Application number: 2022/90958	
What is the application for?:	Erection of single storey extension and alterations to integral garage to extend
Address of the site or building:	152, Soothill Lane, Soothill, Batley, WF17 6HP
Postcode:	WF17 6HP

EXISTING ELEVATIONS.

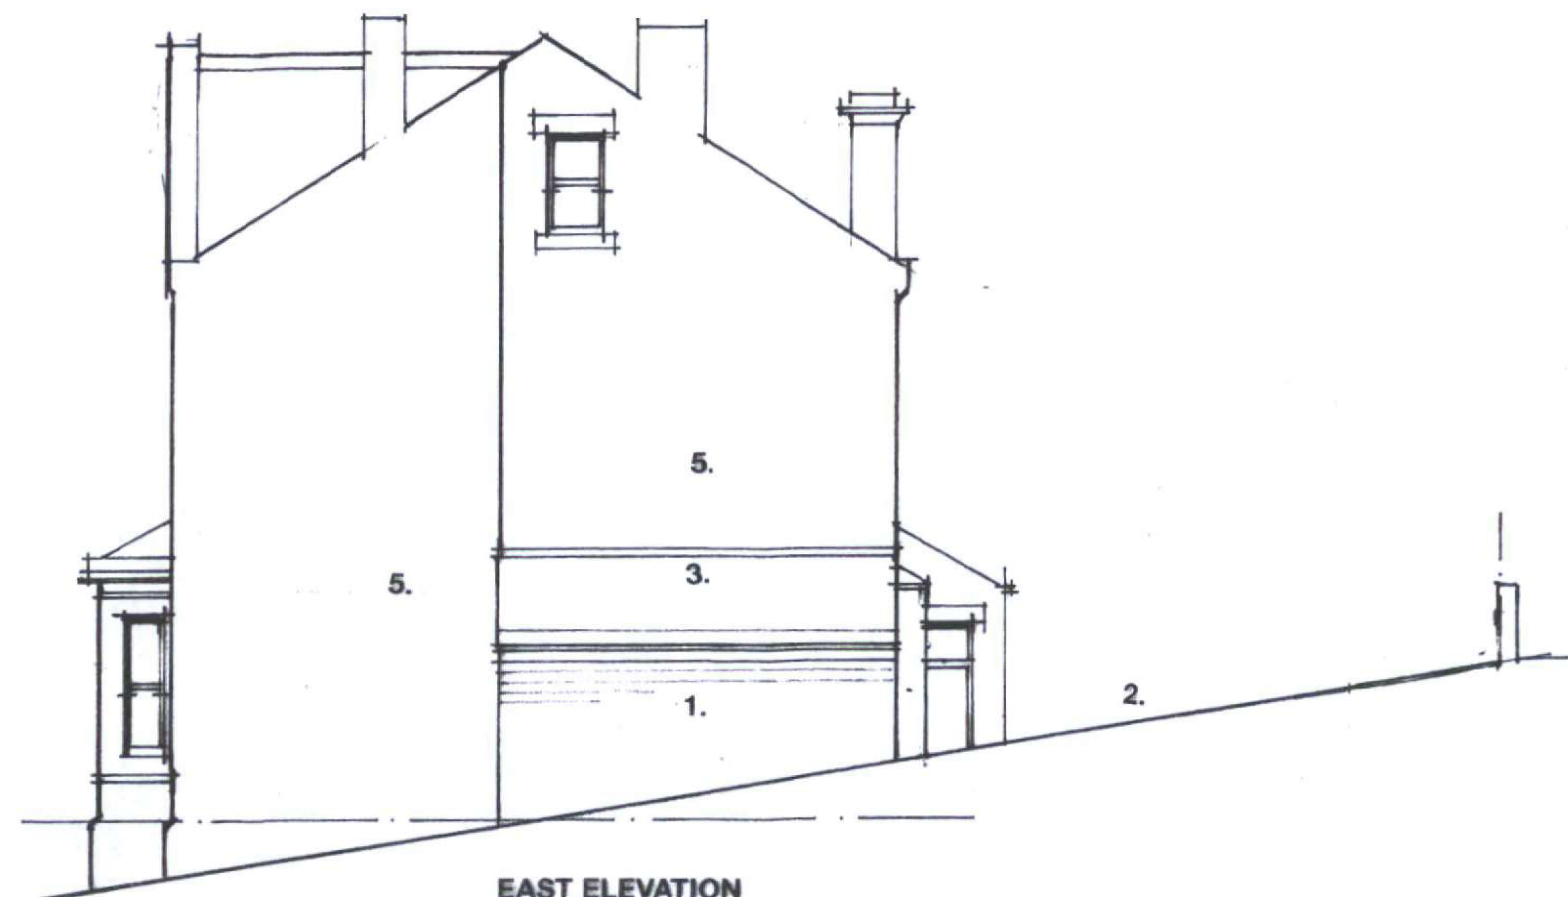
Type of comment: A general comment	
Do you wish your comments to be published on the website anonymously?	Yes
On the plans, there is an existing tree at the corner of the rear of property that has been missed off in the plans. We would like to know if this tree will remain or be removed? As previously discussed numerous times with the occupants, our preference would be for this tree to be removed as it has caused extensive damage in the neighbouring property on previous occasions.
